Address: 1, Woodward Court, Mirfield, Wf140py

Application number: 2025/93355	
What is the application for?:	Erection of 75 residential dwellings with associated landscaping, open space, hi
Address of the site or building:	Land off, Woodward Court, Mirfield, WF14 0PY
Postcode:	LS15 8ZB

TITLE	HEPWORTH LANE / FLASH LANE / SHILLBANK LANE EXISTING HIGHWAY LAYOUT
REF	FIGURE 11
SCALE	1:200 @ A3

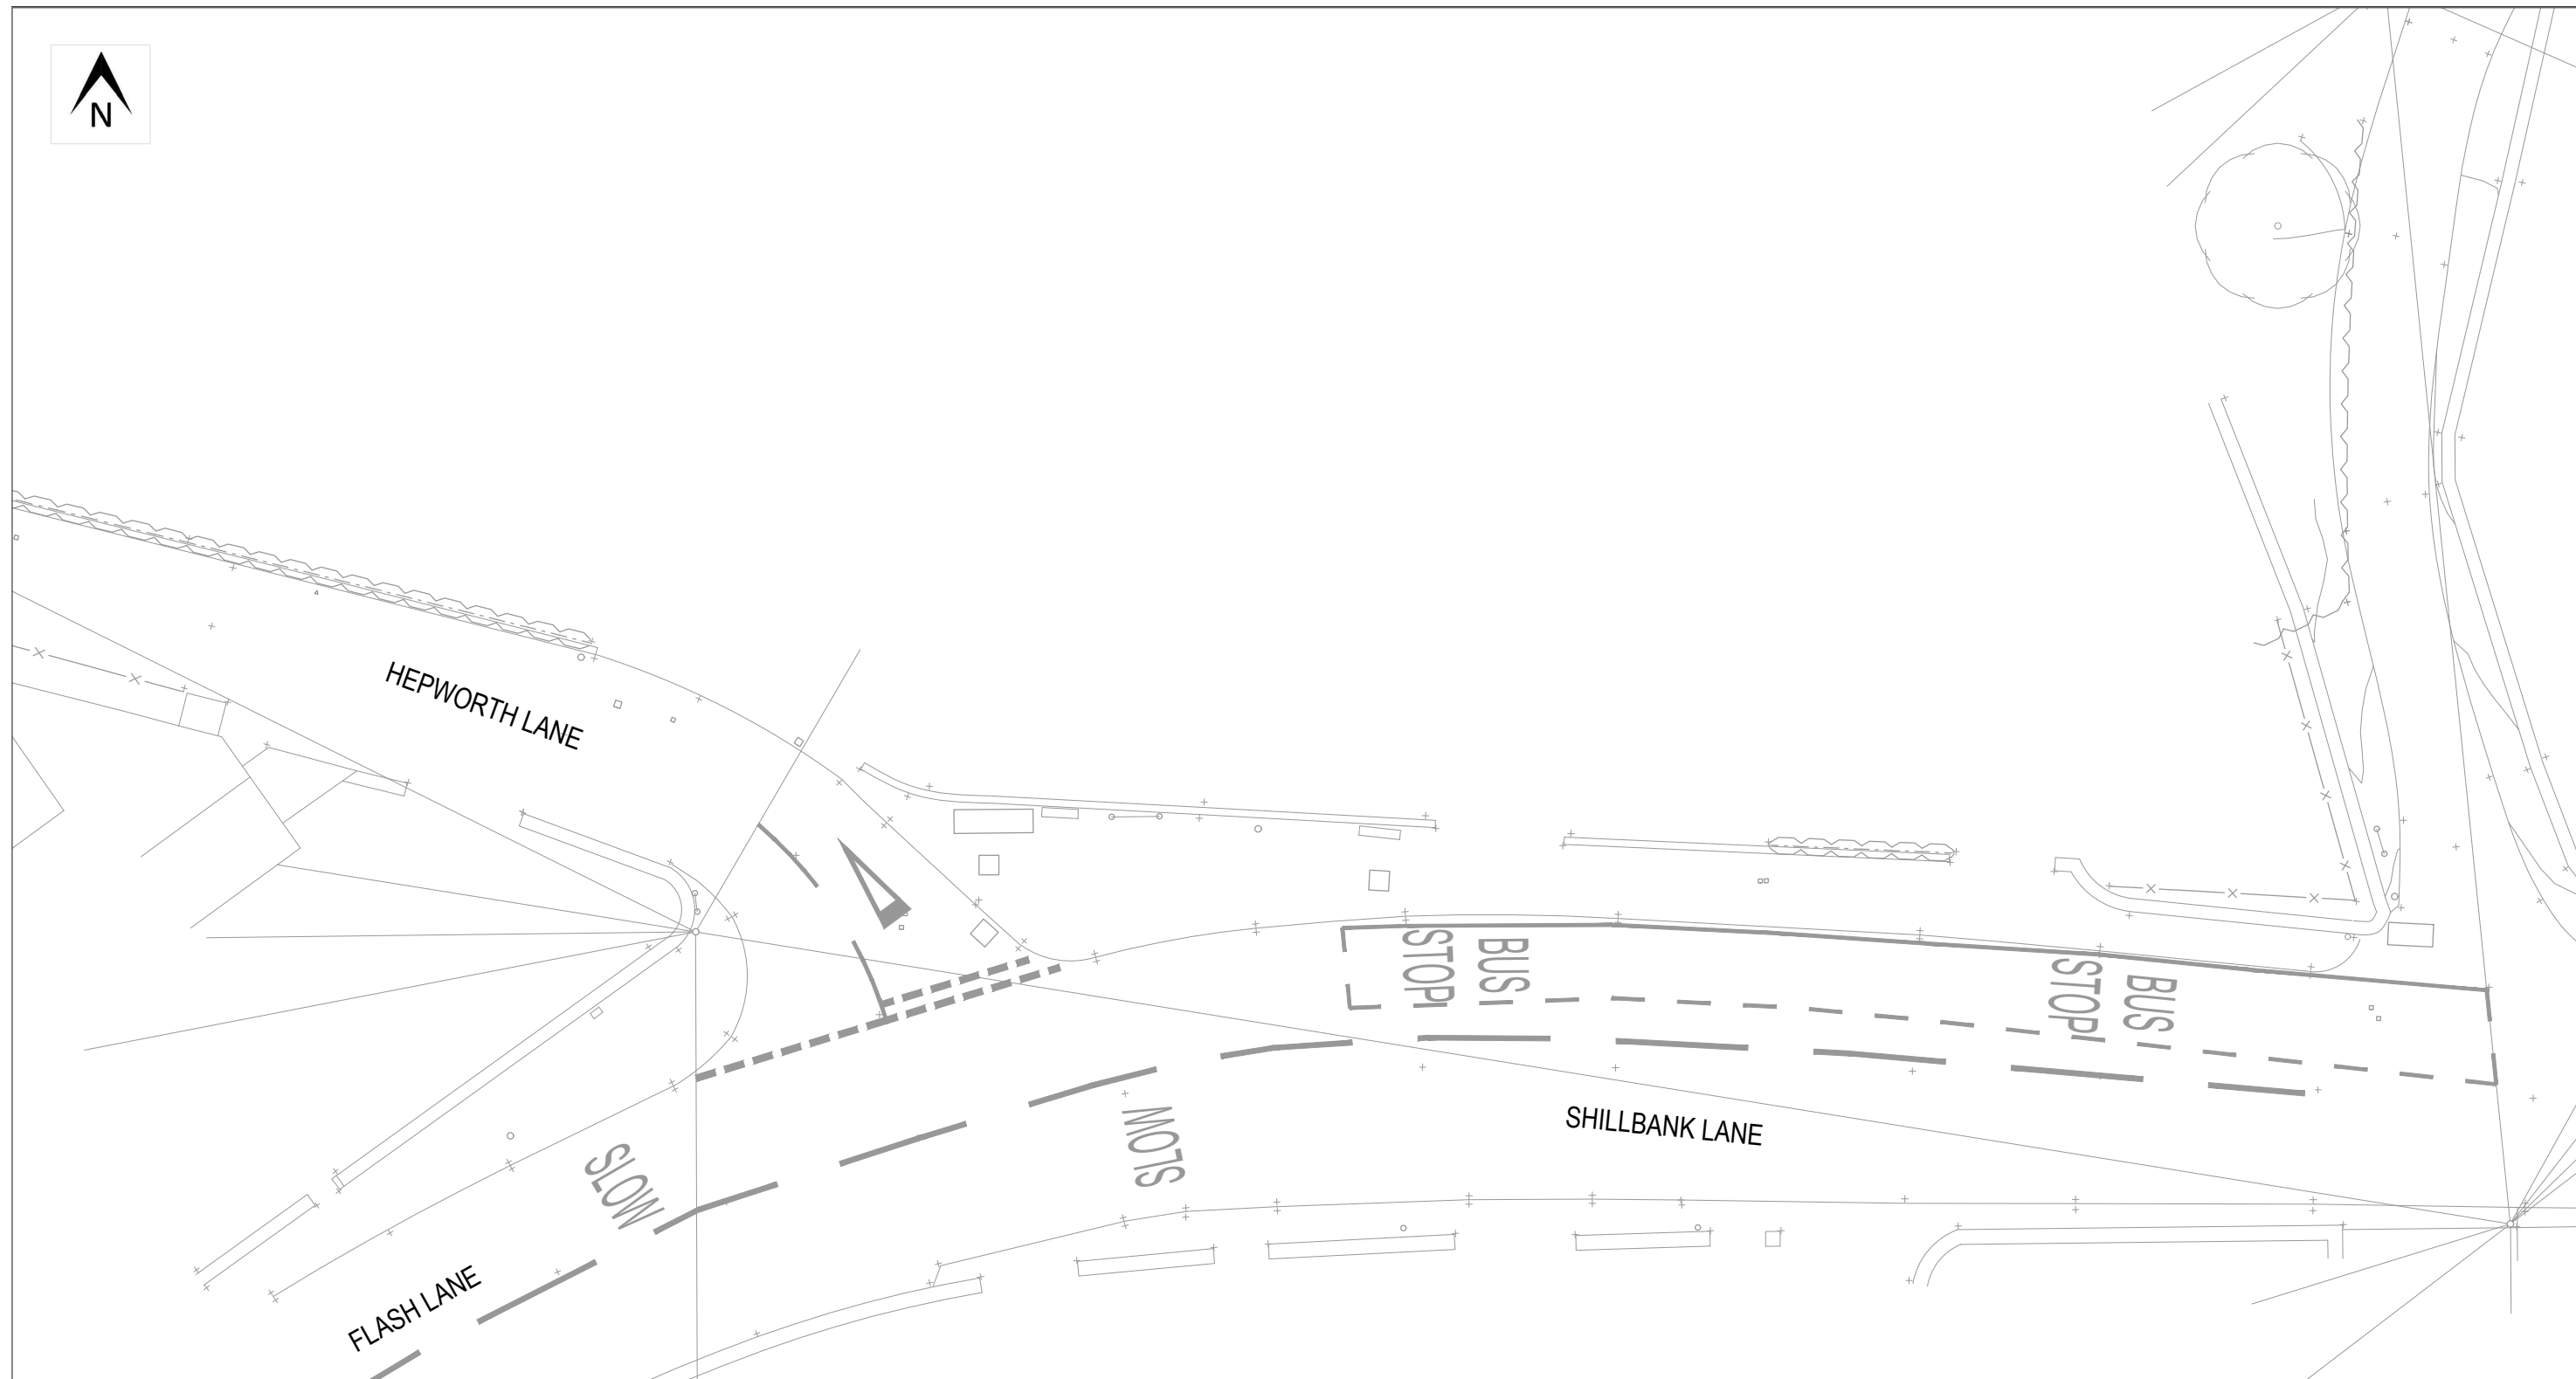
Furthermore, Hepworth Lane and the southern entrance of Wellhouse Lane must not be used for construction traffic of any kind. Both routes are too narrow, too constrained by parking and too heavily used by pedestrians — including schoolchildren — to safely accommodate construction vehicles. Allowing construction traffic on these roads would create unacceptable risks and severe disruption.

TITLE WELLHOUSE LANE/FLASH LANE  
EXISTING HIGHWAY LAYOUT

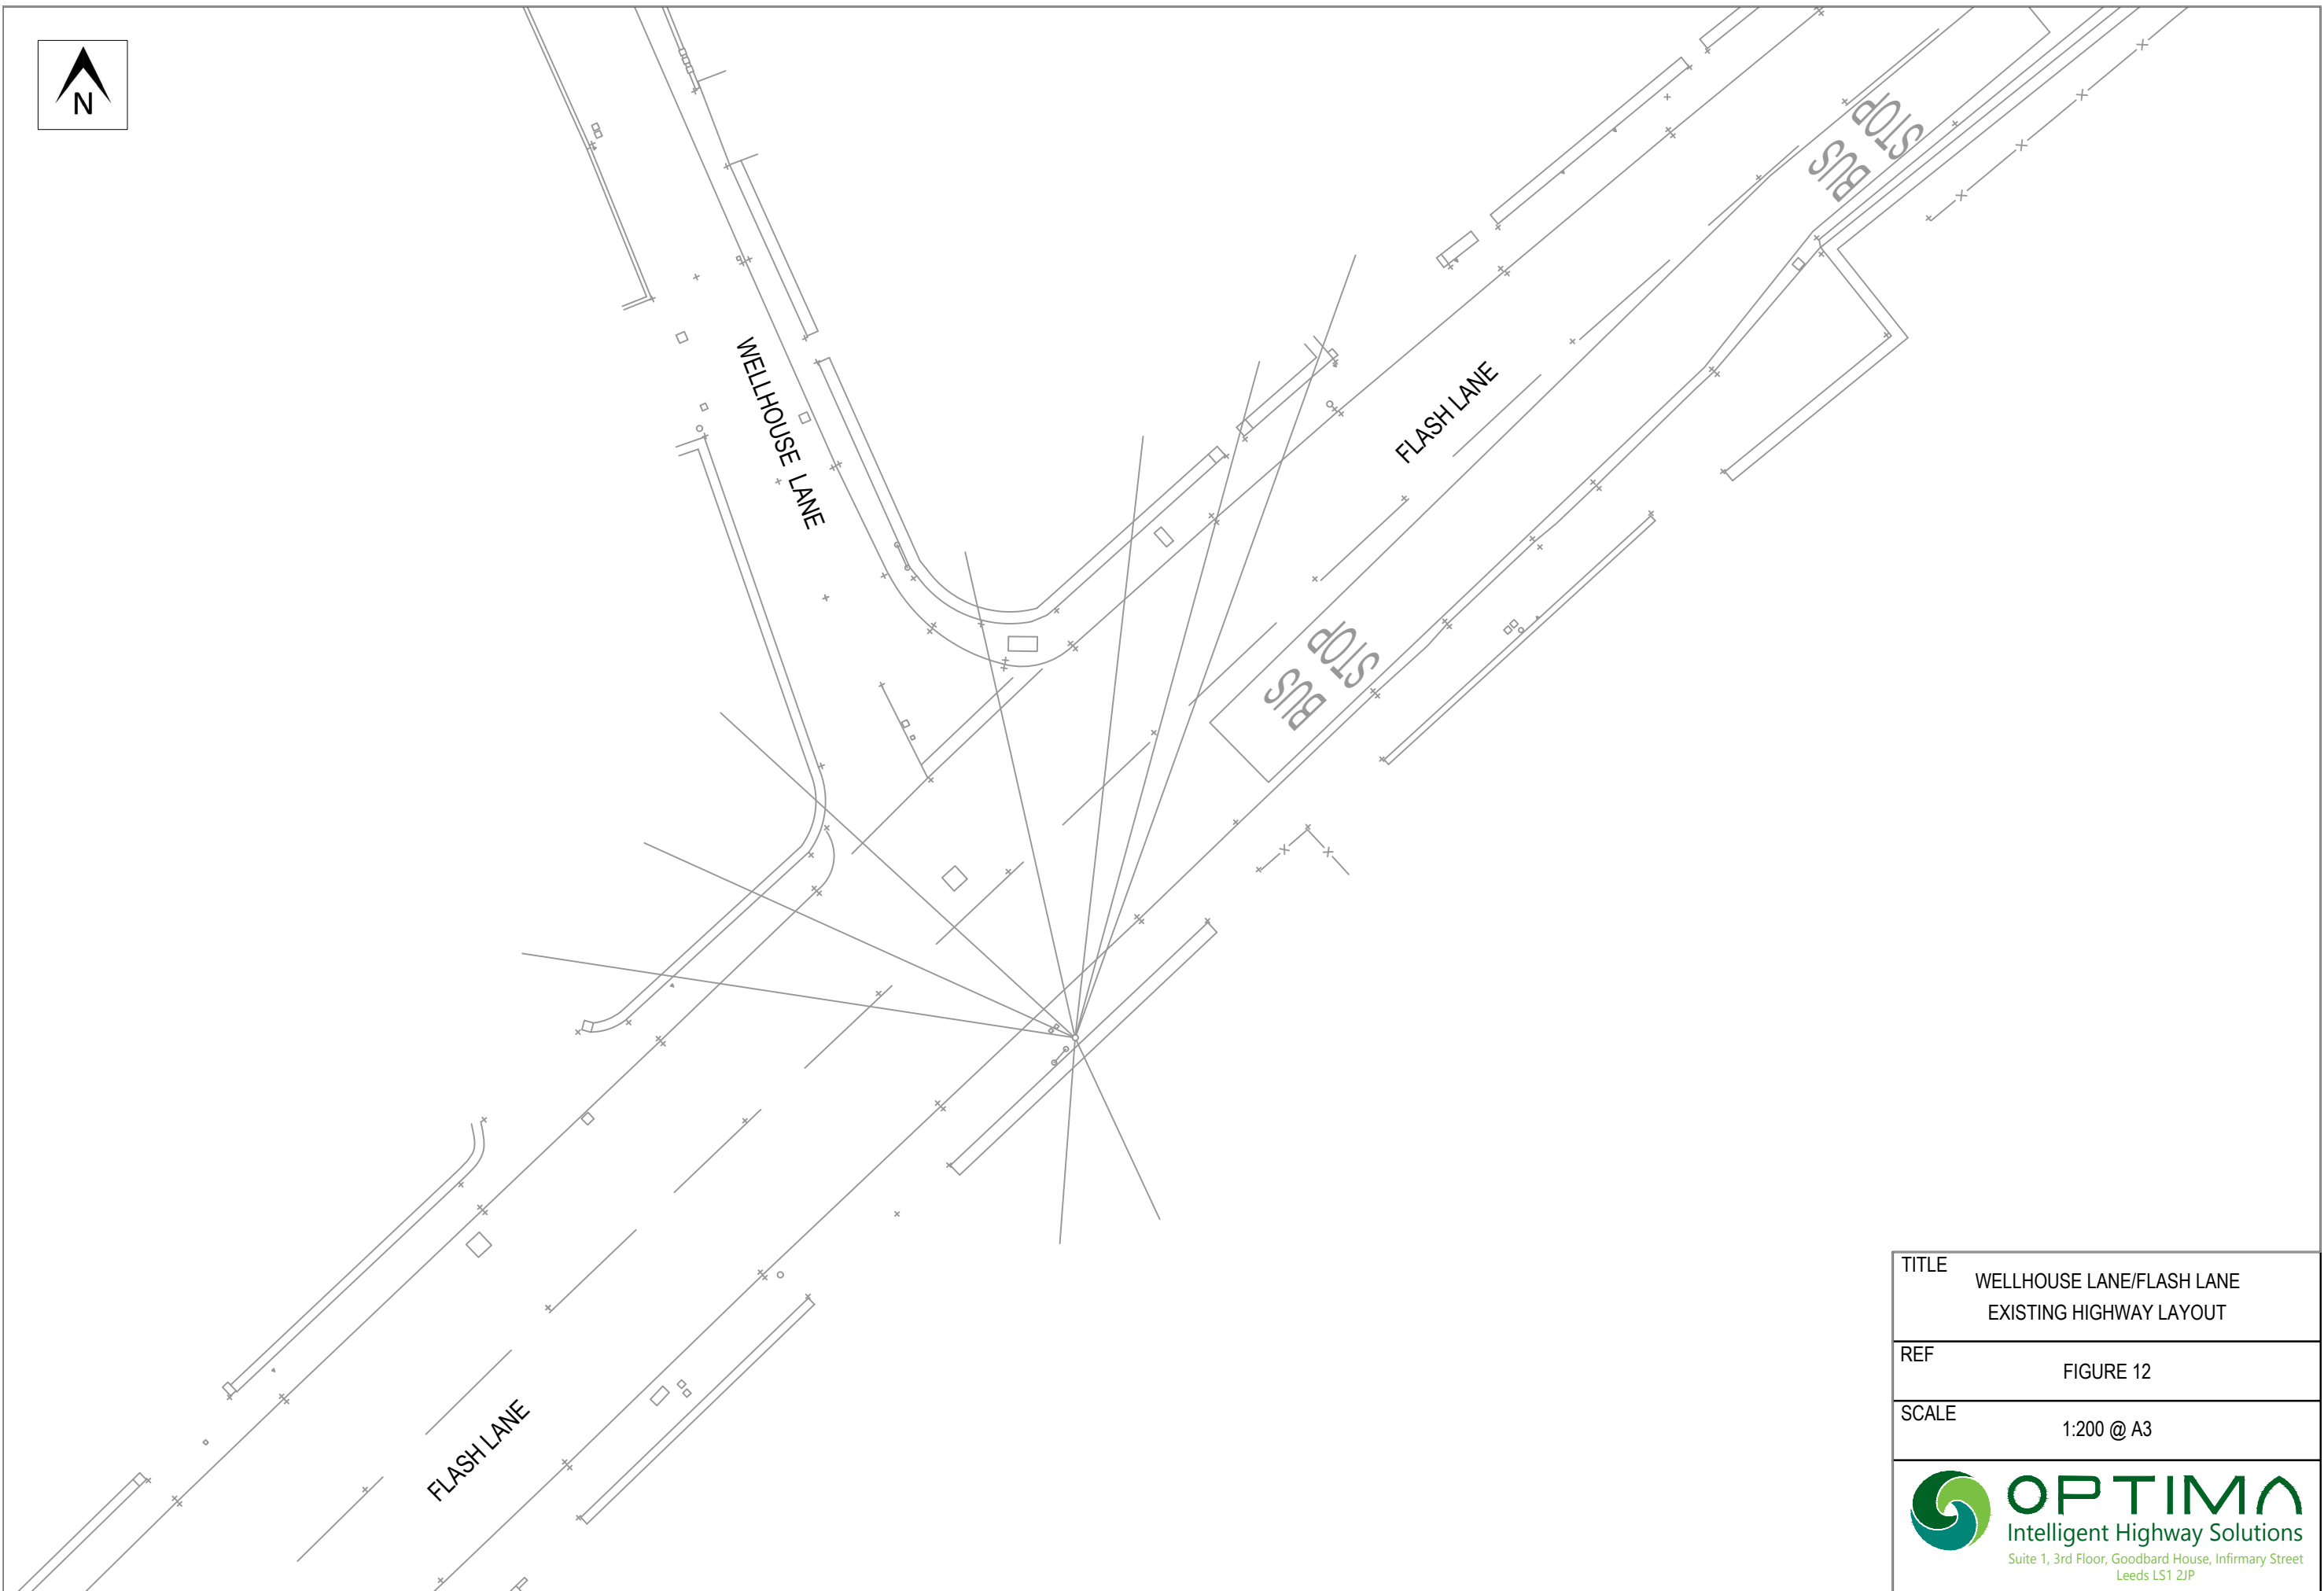
- A vehicle the size of a coach would only have a realistic chance of accessing the area between approximately 10am and 2pm, when school related traffic is at its lowest.
- Anything larger than a coach would not realistically be able to make its way down Wellhouse Lane at all, given the width restrictions, parking patterns and tight geometry.
